20 Sep 2012

Response to RPAH North West Precinct Development (MP 10_0166)

DEPARTMENT OF PLANNING SUBMISSION
PHOTOMONTAGE PERSPECTIVE - SHEET 1
ROYAL PRINCE ALFRED HOSPITAL
North West Precinct Project, Camperdown

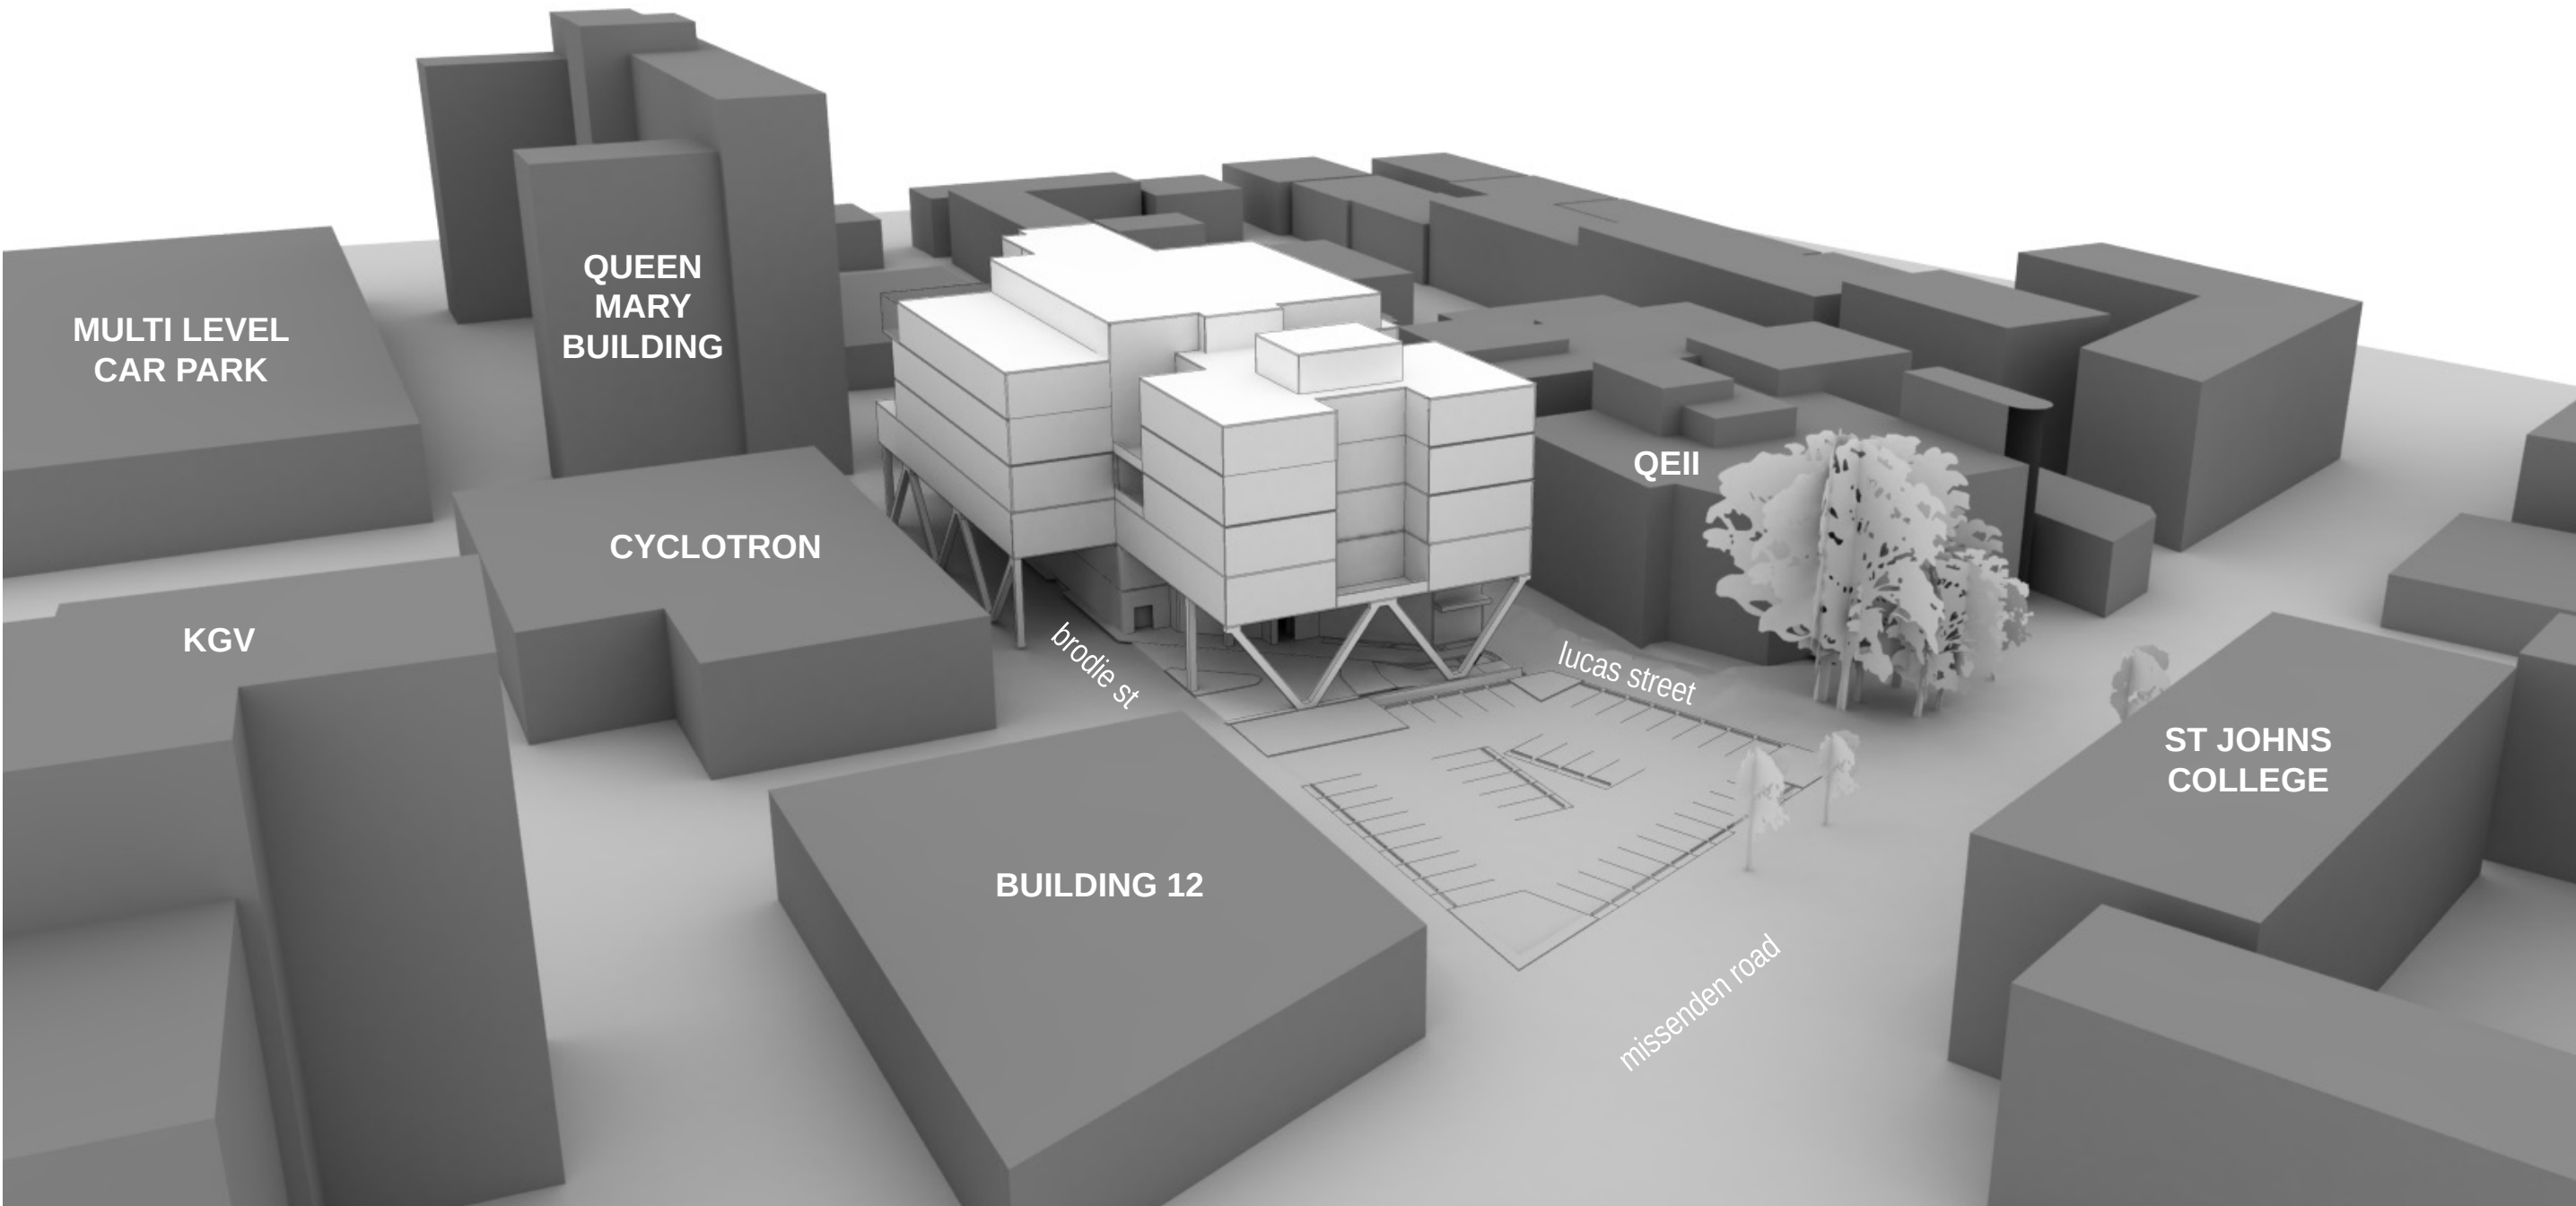
1. Prominent white angled supporting concrete pillars

The pillars appear to have been designed as a deliberately prominent part of the building, whose prominence is enhanced by:

- Obliqueness - the angles are in sharp contrast to the horizontal-vertical planes of the rest of this building and most other surrounding built structures
- Brightness - the bright white colour is another sharp contrast to the muted tones of brick, concrete and other usual building materials
- Connectedness - the pillars form a strong zigzag at the base of the building which wraps around its sides and connects to the other white horizontal-vertical elements.

2. Facade

Like the pillars, the patterned precast concrete of the facade facing Missenden Rd appears to have been designed as a deliberately prominent part of the building, whose prominence is enhanced by the number of same-width lines at different angles and rectangular cutouts revealing the glass.

3. Triangular side features

The Lucas St base of the building appears to be faced with large grey and white triangles.

- Pillars - a more neutral or "invisible" colour instead of white, to increase the impression that the building "floats"; wrapping the pillars in a vine to give the impression of an organic support; or increasing the extent of the existing trellis to fill but not occlude the inter-pillar spaces.
- Facade - use of a different textured or patterned material with curved lines or sections.
- Side - use of a non-adherent vine on a close mesh trellis.
